RIBBLE VALLEY BOROUGH COUNCIL  
Development Department  
Council Offices, Church Walk, Clitheroe, Lancashire, BB7 2RA  
Telephone: 01200 425111 [www.ribblevalley.gov.uk](http://www.ribblevalley.gov.uk)  
[planning@ribblevalley.gov.uk](mailto:planning@ribblevalley.gov.uk)

please ask for: Maya Cullen  
direct line: 01200 425111  
my ref: 3/2026/0296  
your ref:  
date: 08 June 2026

TOWN AND COUNTRY PLANNING (GENERAL PERMITTED DEVELOPMENT) ORDER 2015 (AS AMENDED) SCHEDULE 2, PART 16, CLASS A PRIOR NOTIFICATION OF ELECTRONIC COMMUNICATIONS CODE OPERATORS

Proposal: Prior notification for proposed installation of a 15m telegraph pole supporting 3no. antennas, 2x 0.3m dishes, 3no. equipment cabinets and ancillary development thereto including 1.2m fence with 3m double access gates and underground cabling.

Title: **250 PROPOSED SITE ELEVATION**

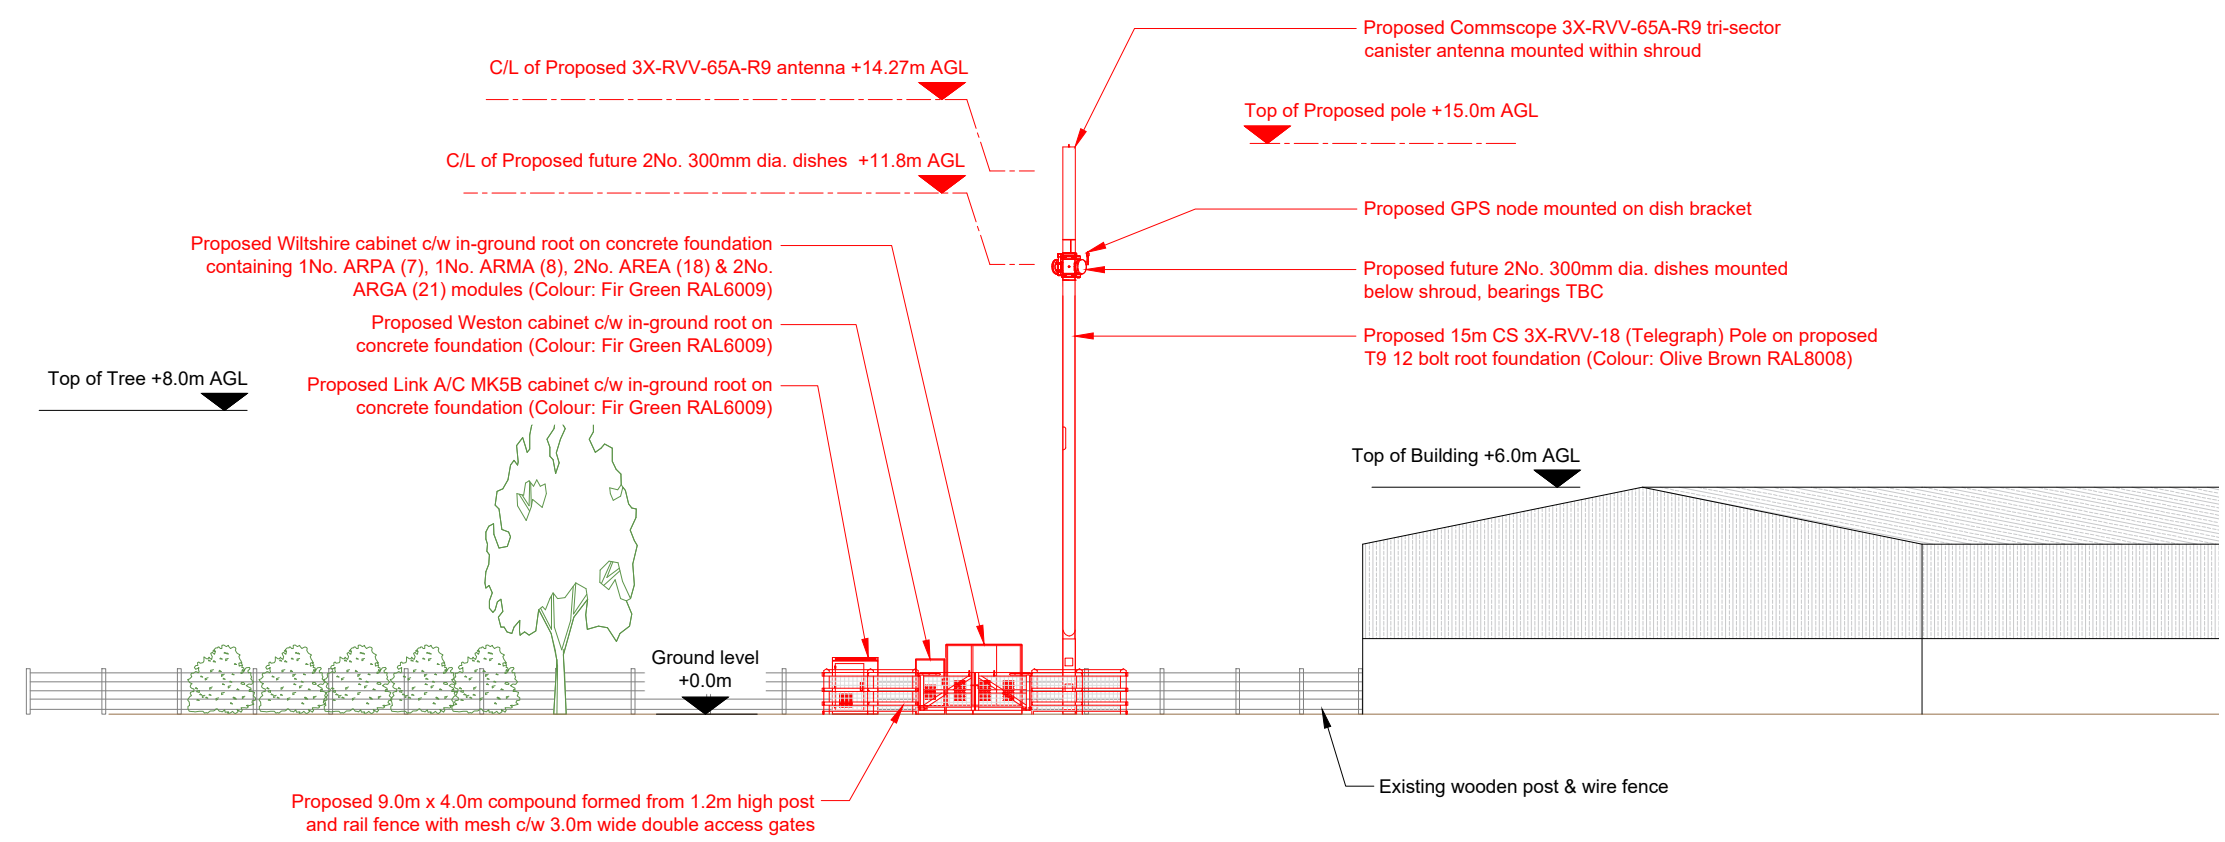
- 1 Prior approval is required and refused in respect of siting and appearance as the proposal is considered to result in an incongruous development within the Forest of Bowland National Landscape that would result in harm to the landscape and character, failing to conserve or enhance the scenic beauty of the Forest of Bowland National Landscape, contrary to Key Statement EN2, and Policies DMG1 and DMG2 of the Ribble Valley Core Strategy and the aims and objectives of Para.189 of the National Planning Policy Framework.
